From: Claire Booth
Sent: 06 February 2013 16:21
To: Jane Tucker
Subject: FW: 3/2012/1116 Salthill Road Clitheroe

From: Lewis, Trevor [mailto:Trevor.Lewis@lancashire.gov.uk]
Sent: 06 February 2013 14:22
To: Claire Booth
Subject: 3/2012/1116 Salthill Road Clitheroe

Ground Floor Plan

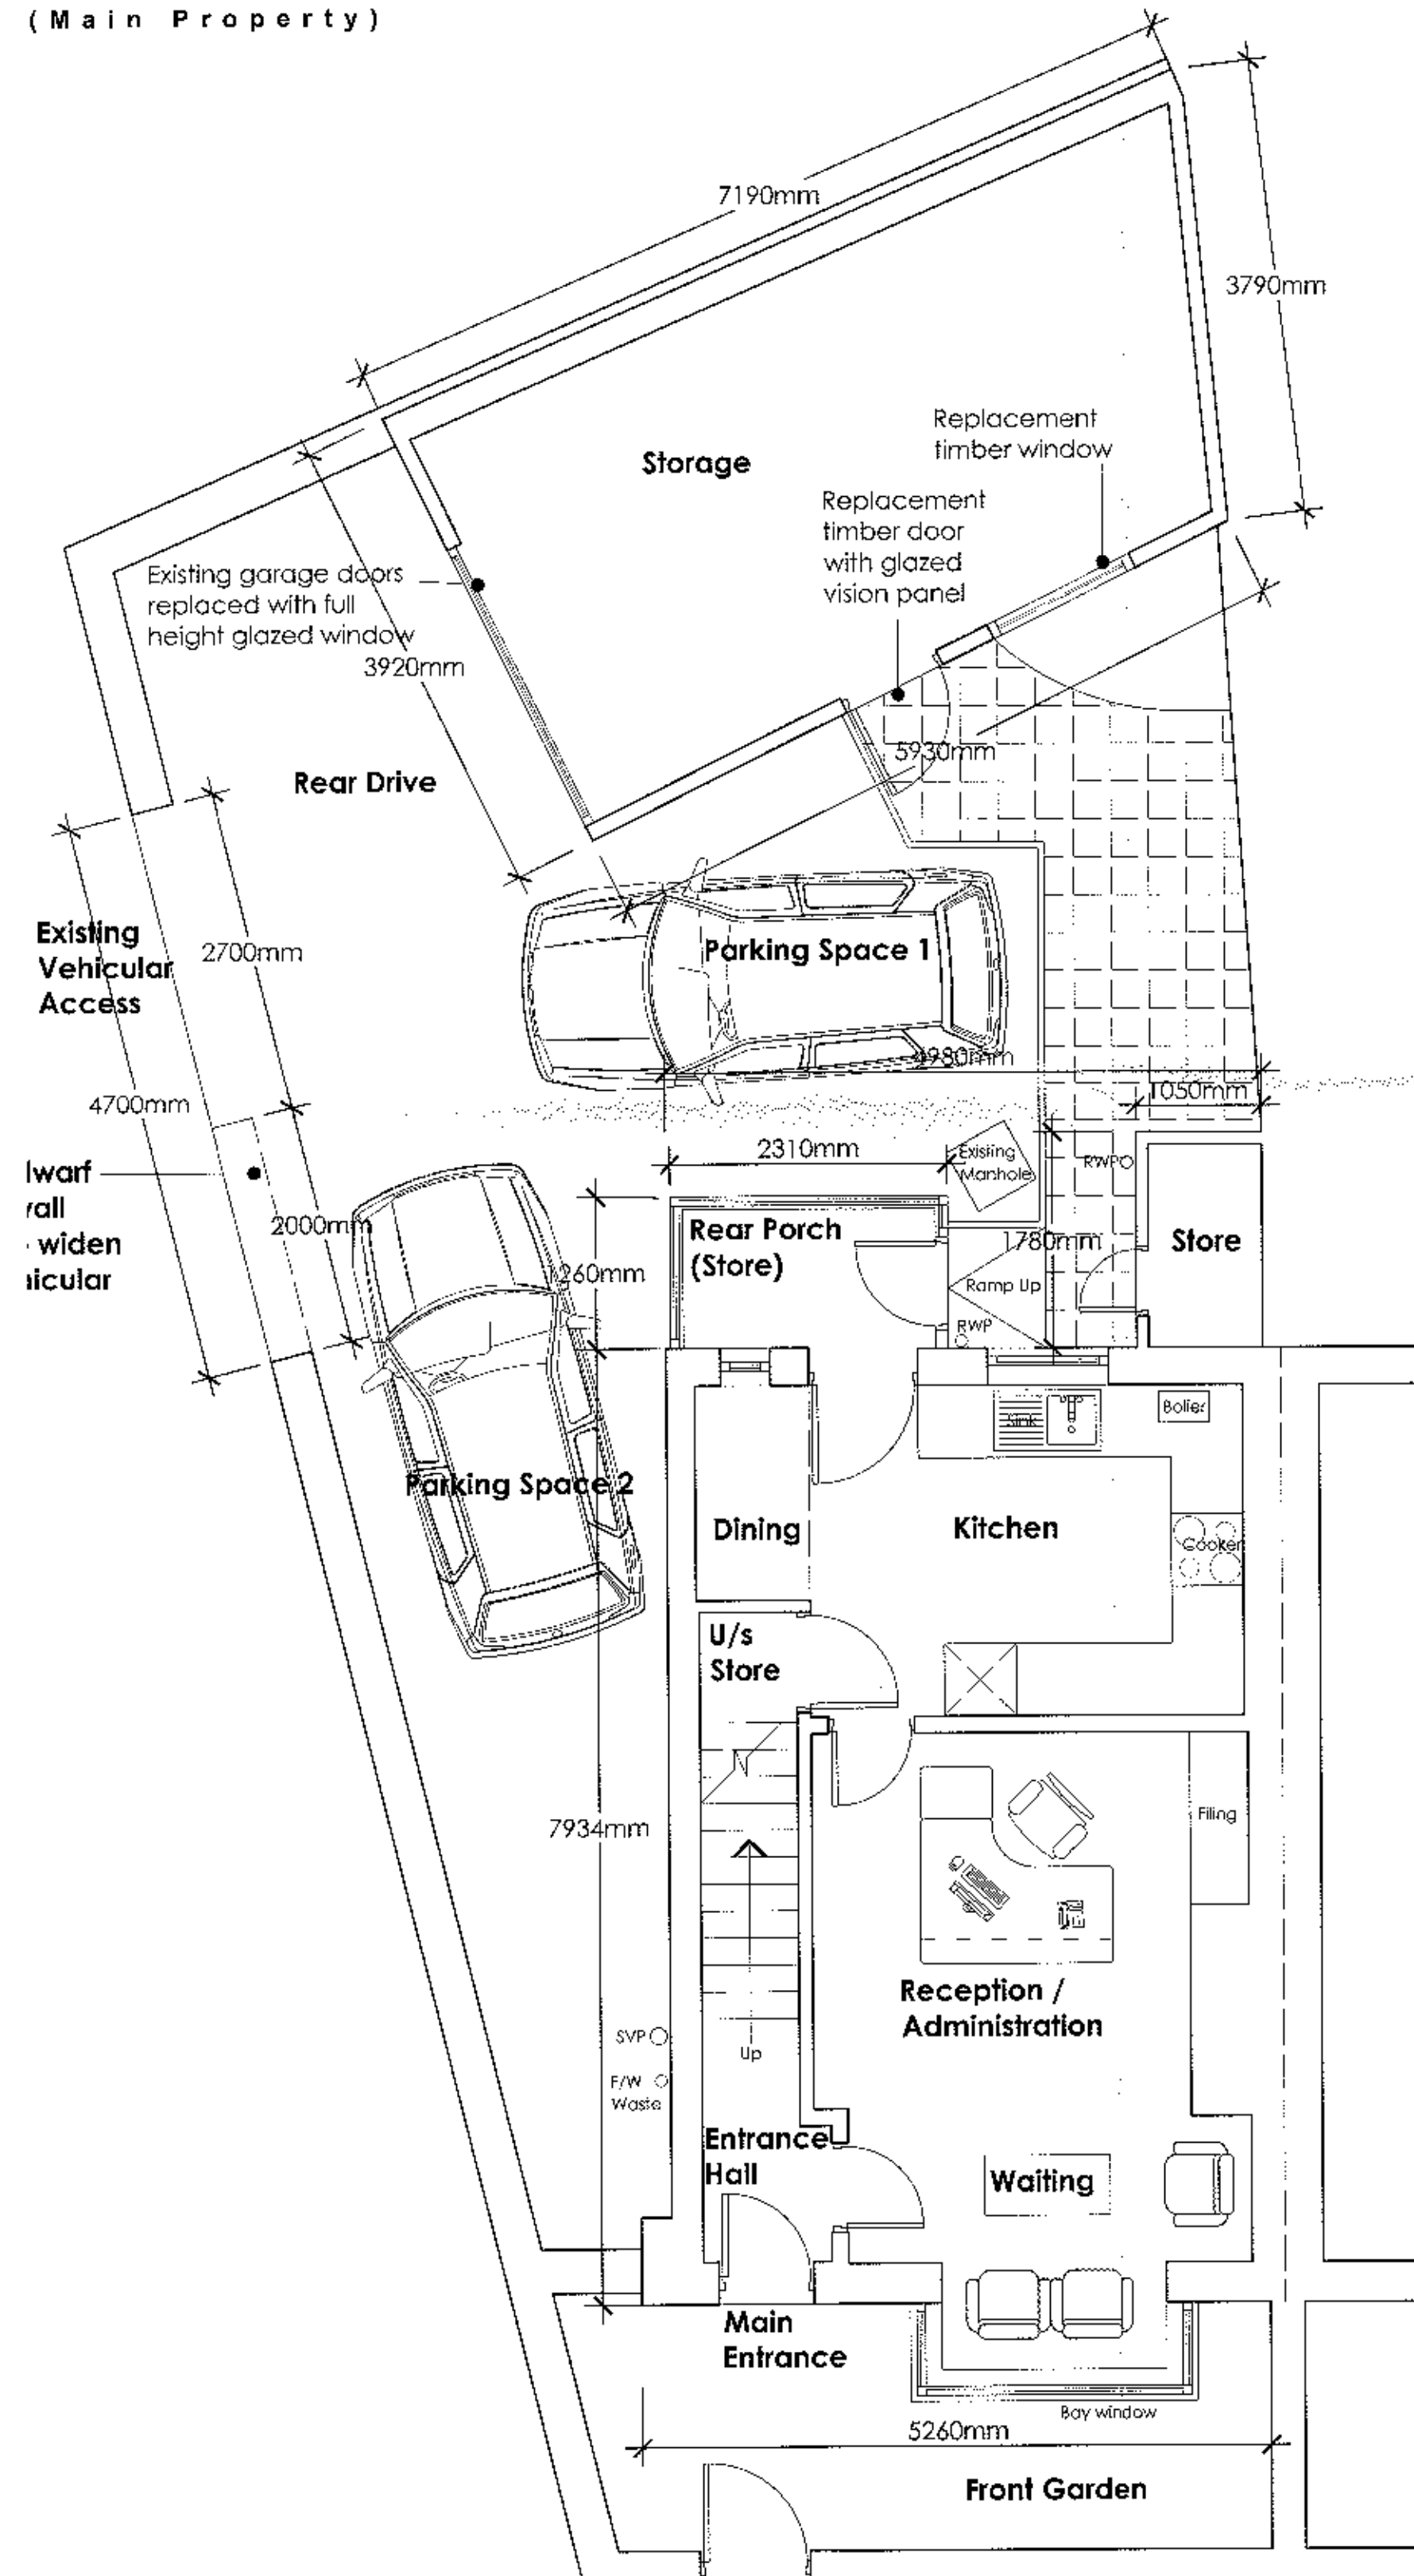
The layout of the rear yard indicates there are two parking spaces; but the parking spaces are shown by the image of a car in each proposed parking space. These spaces are in fact much smaller than the recommended size of parking bay, which is 2.4m by 5m.

Please ask the developer to show that there is sufficient space on site for two regular sized parking spaces. There should also be space for vehicles to turn around within the property and drive out in forward gear.

The layout of the development shall include provisions to enable vehicles to enter and leave the highway in forward gear and the vehicular turning space shall be laid out and be available for use before the development is brought into use. Reason: Vehicles reversing to and from the highway are a hazard to other road users.
